Date: 17-Feb-2026
Our Ref: 2026/90164

**TOWN AND COUNTRY PLANNING ACT 1990
TOWN AND COUNTRY PLANNING (GENERAL PERMITTED DEVELOPMENT) (ENGLAND)
ORDER 2015 – SCHEDULE 2, PART 1, CLASS A.1 (g)
AT: 42, Thomas Street, Lindley, Huddersfield, HD3 3JJ
Prior notification for single storey rear extension**

The Authority has considered your application and it has been determined that the proposal is not acceptable and prior approval is hereby **Refused** for the following reason(s);

proposed single storey extension

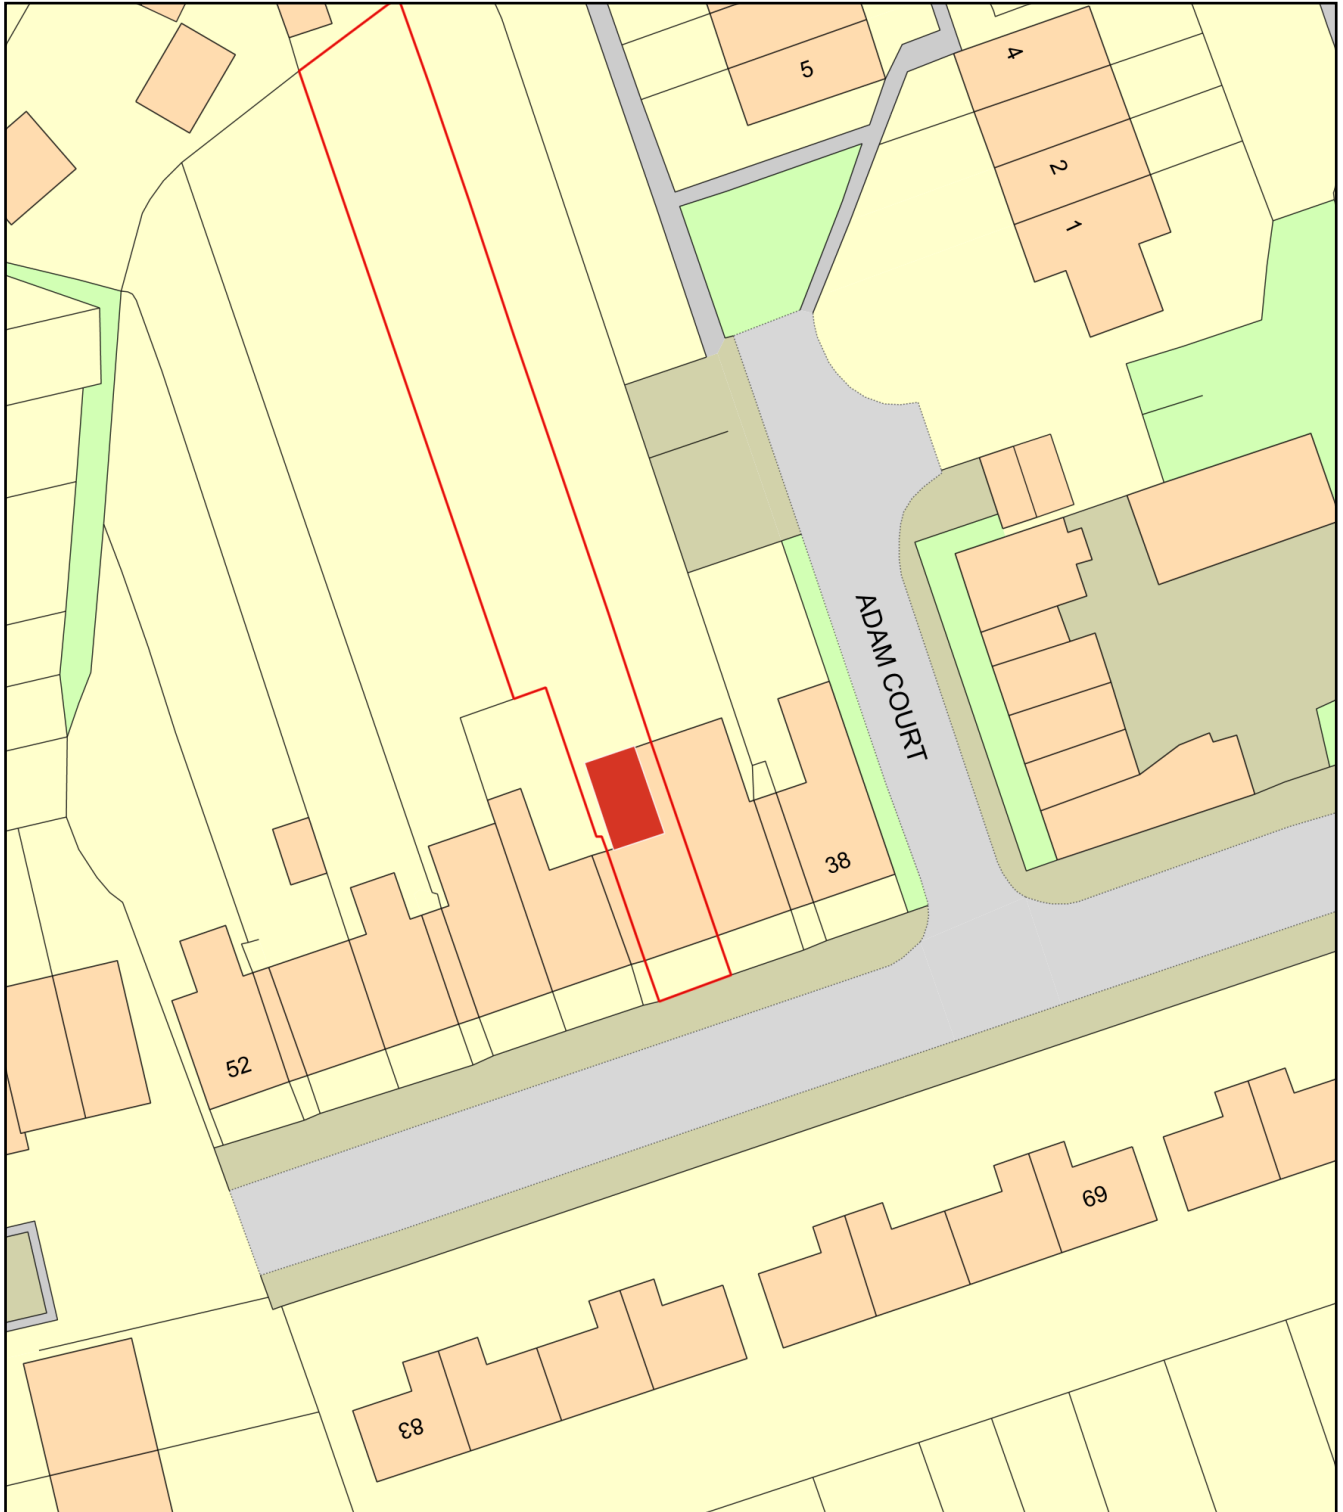
The proposed enlargement cannot benefit from a general planning permission granted under Article 3(1) and Schedule 2, Part 1, Class A of the Town and Country Planning (General Permitted Development)(England) Order 2015 (as amended) as the proposed enlargement would project from a side elevation of the original dwellinghouse contrary to sub-paragraph A.1(j) of Class A.
